**RE: Bradley Heights PUD Development Plan – Initial Review Comments  
File # AR PUD 21-00206**

The proposed project involves a PUD development plan to enable development of a vacant parcel into 168 single-family residences. Staff finds that the application is largely acceptable; however, the following technical modifications must be completed.

SMALL LOT PUD DEVELOPMENT PLAN
 PRELIMINARY GRADING PLAN - SOUTH

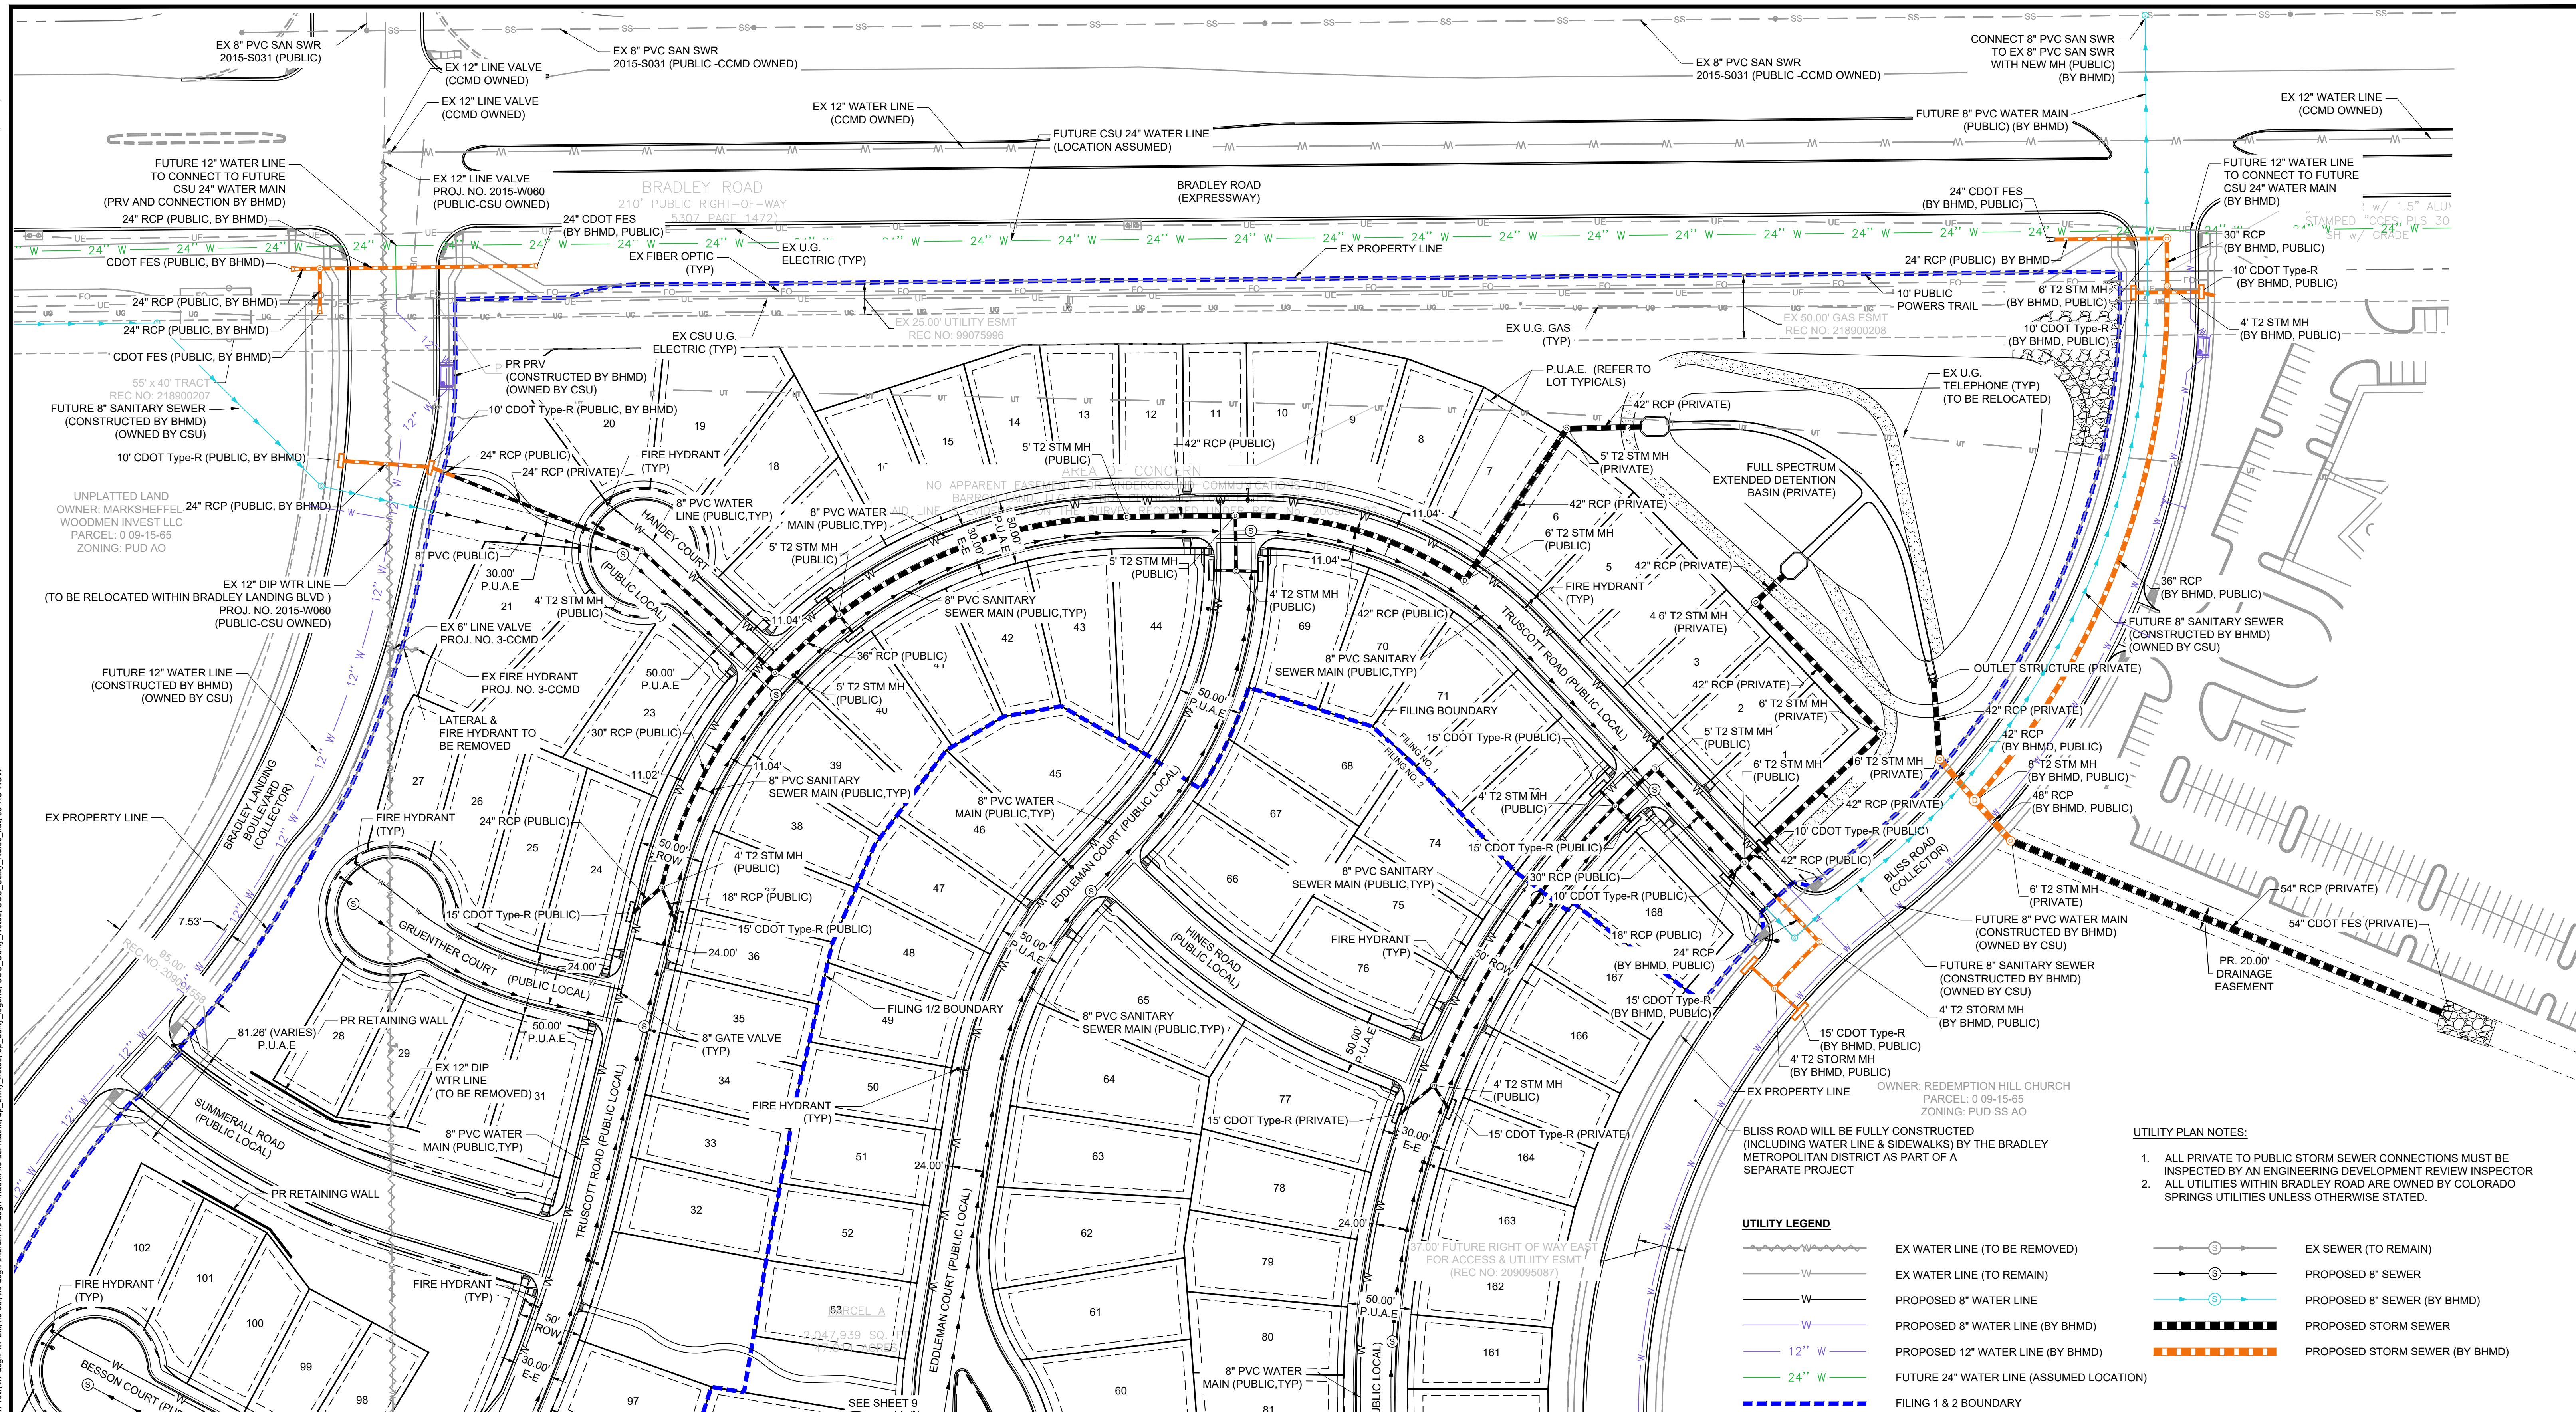
5. Remove note on sheets 4 and 5 stating minimum driveway length is 15 feet. Minimum must be 20 feet.
6. Confirm whether any retaining walls are to be utilized? If so, show on grading plan and denote T.O.W. and B.O.W.

14. Provide dimensions for the width of common area tracts on the site plan.
15. Please show any retaining walls on grading plan and landscape plans, and identify TOW and BOW measurements for all.

SHEET
SP

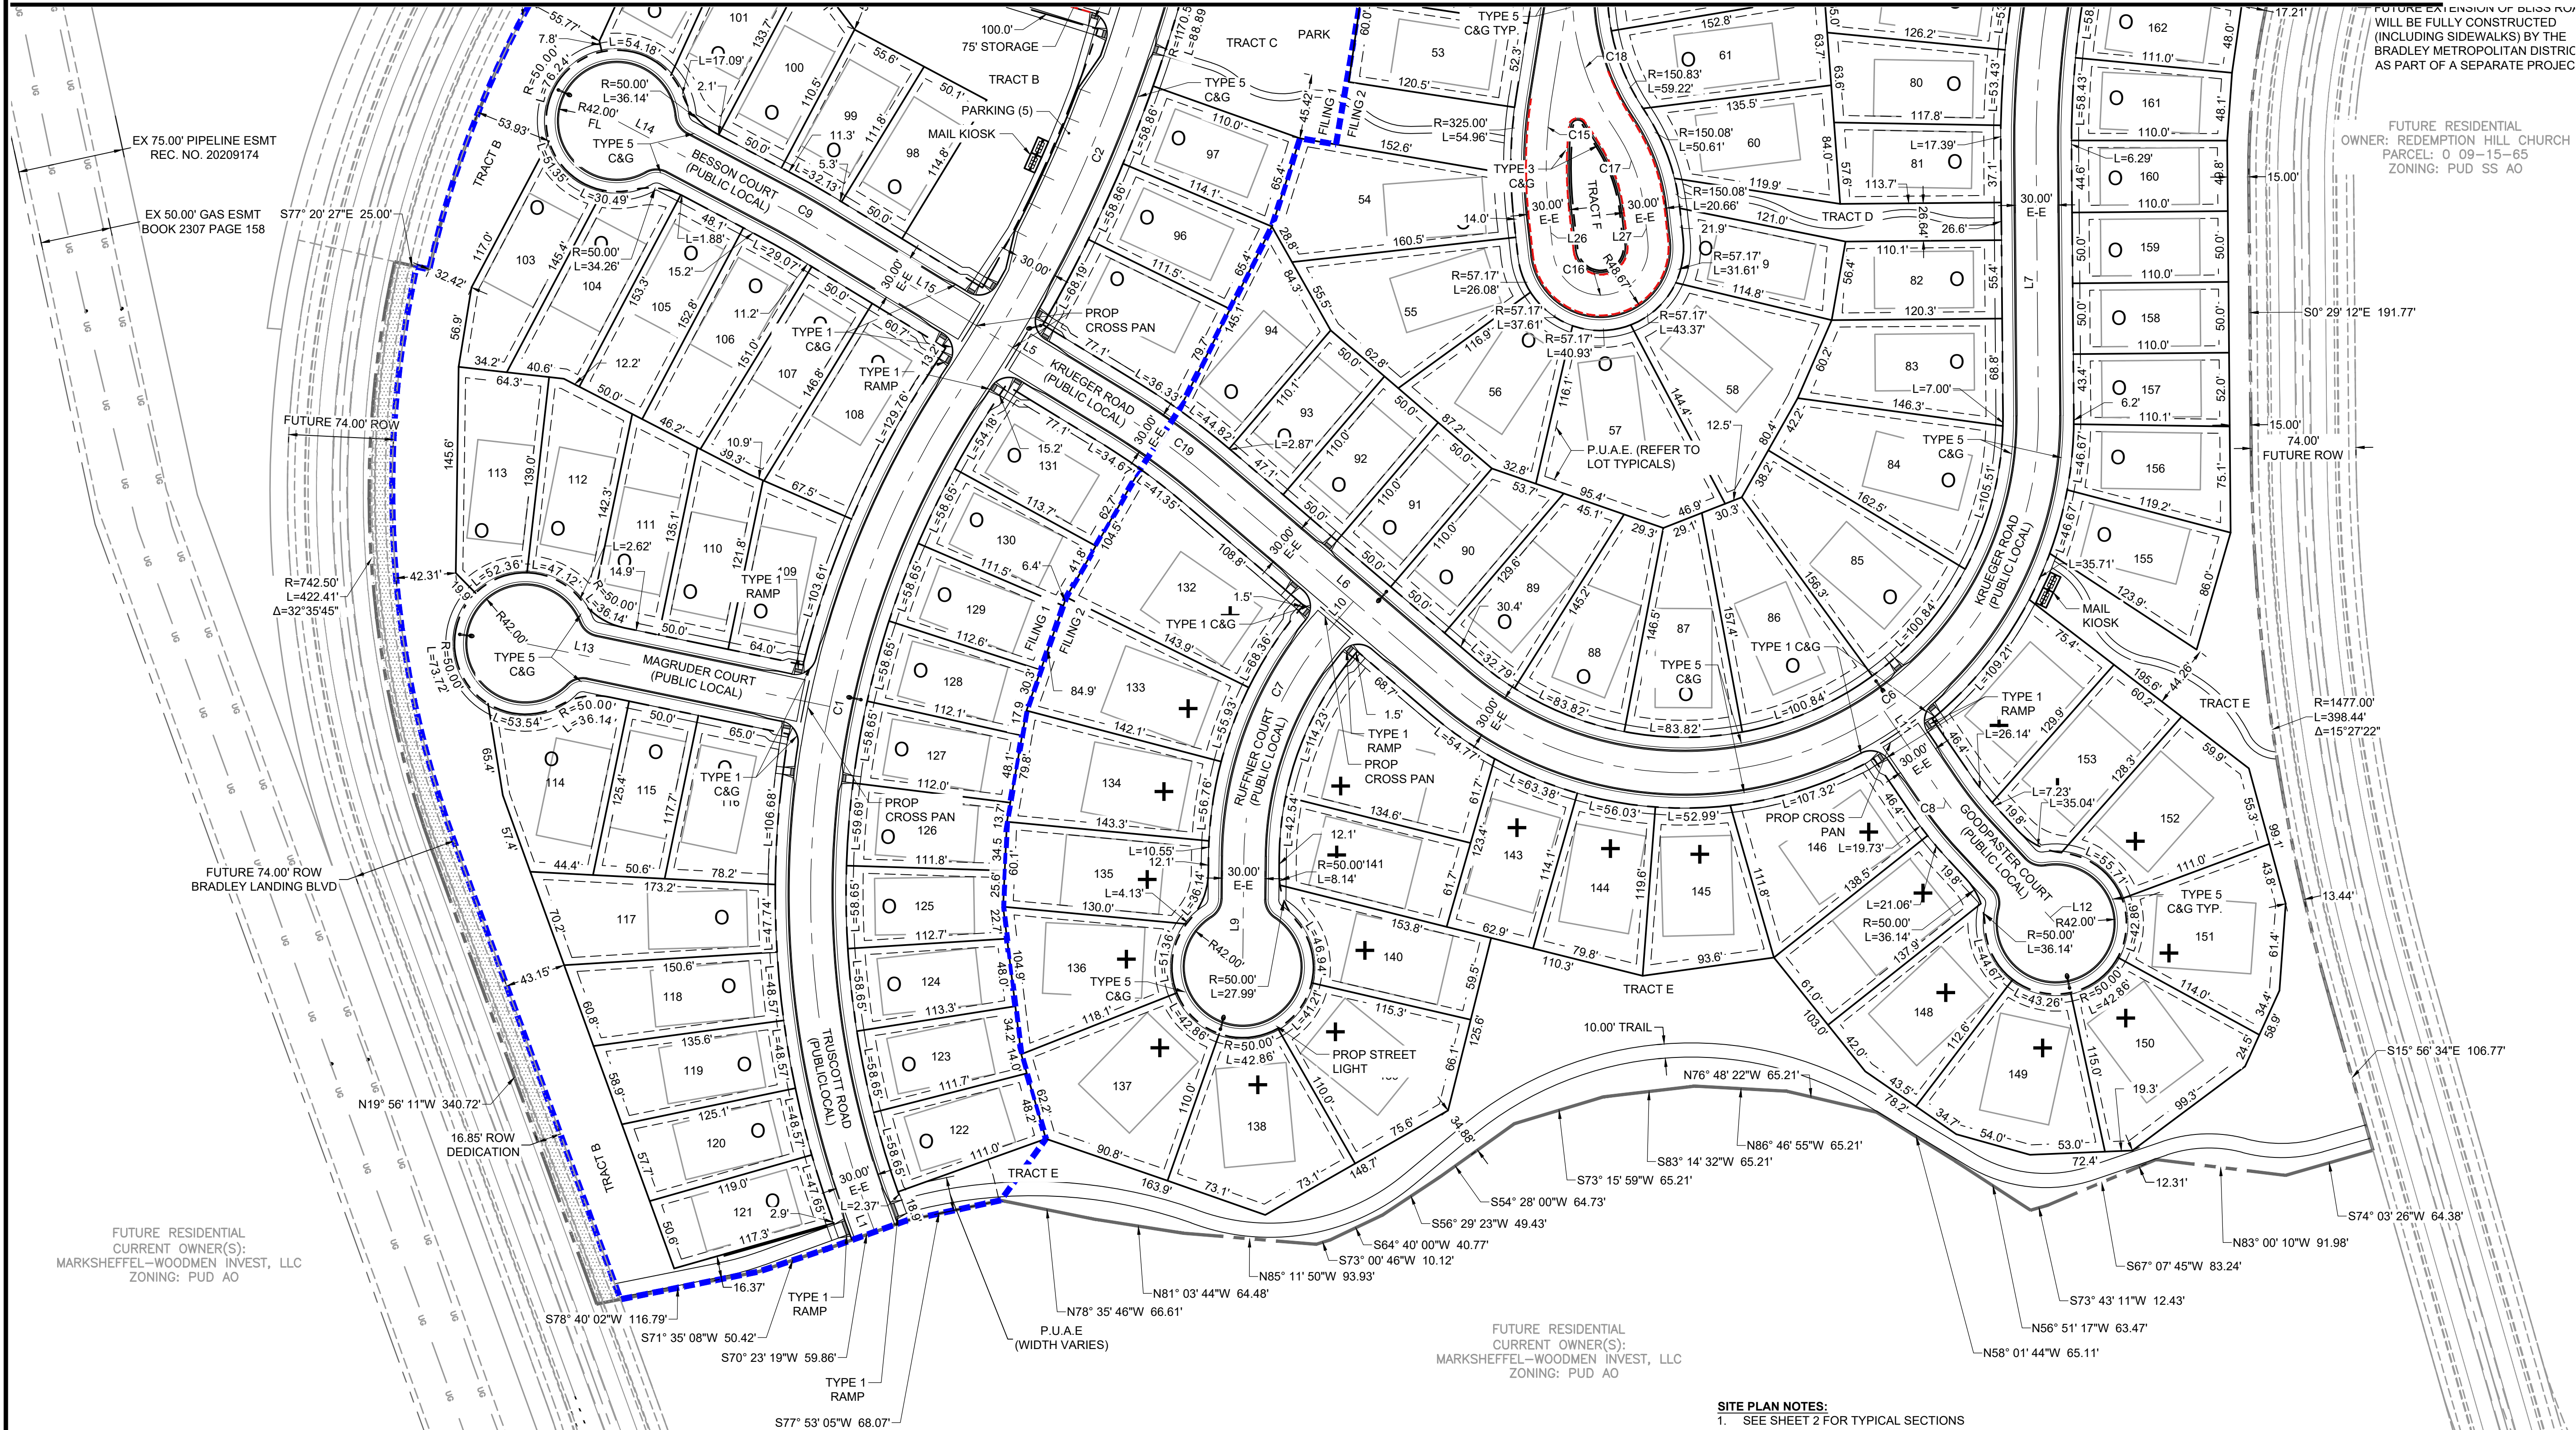
1. Confirm if Challenger Homes will fully construct Bliss Road from Bradley Road to Road Name 1. The Church development plan did not indicate they are constructing Bliss Road. This will require a written agreement between the property owners and possibly adding a note the development plan stating who will construct Bliss Road. This also applies to the Bradley Road median modification to make Bliss Road a full movement intersection. Will Challenger Homes install the sidewalk adjacent to the Church

property and install the proposed driveway into the Church site? In addition, the Church property is proposing platting 37' of the 74' ROW. Will Bradley Heights plat the remaining 37'?

11. Request the Bliss Road improvements stop after Lot 168. When the lot 168 is developed, it will trigger sidewalk improvements along Road Name 2, 1 and Bliss Road. Unless the developer agrees to install all the sidewalk on Bliss Road adjacent to the single family lots. If this is the case, add a note to the development plan stating the construction of Bliss Road will include installing the public sidewalk on the west side of Bliss Road (adjacent to the single family).
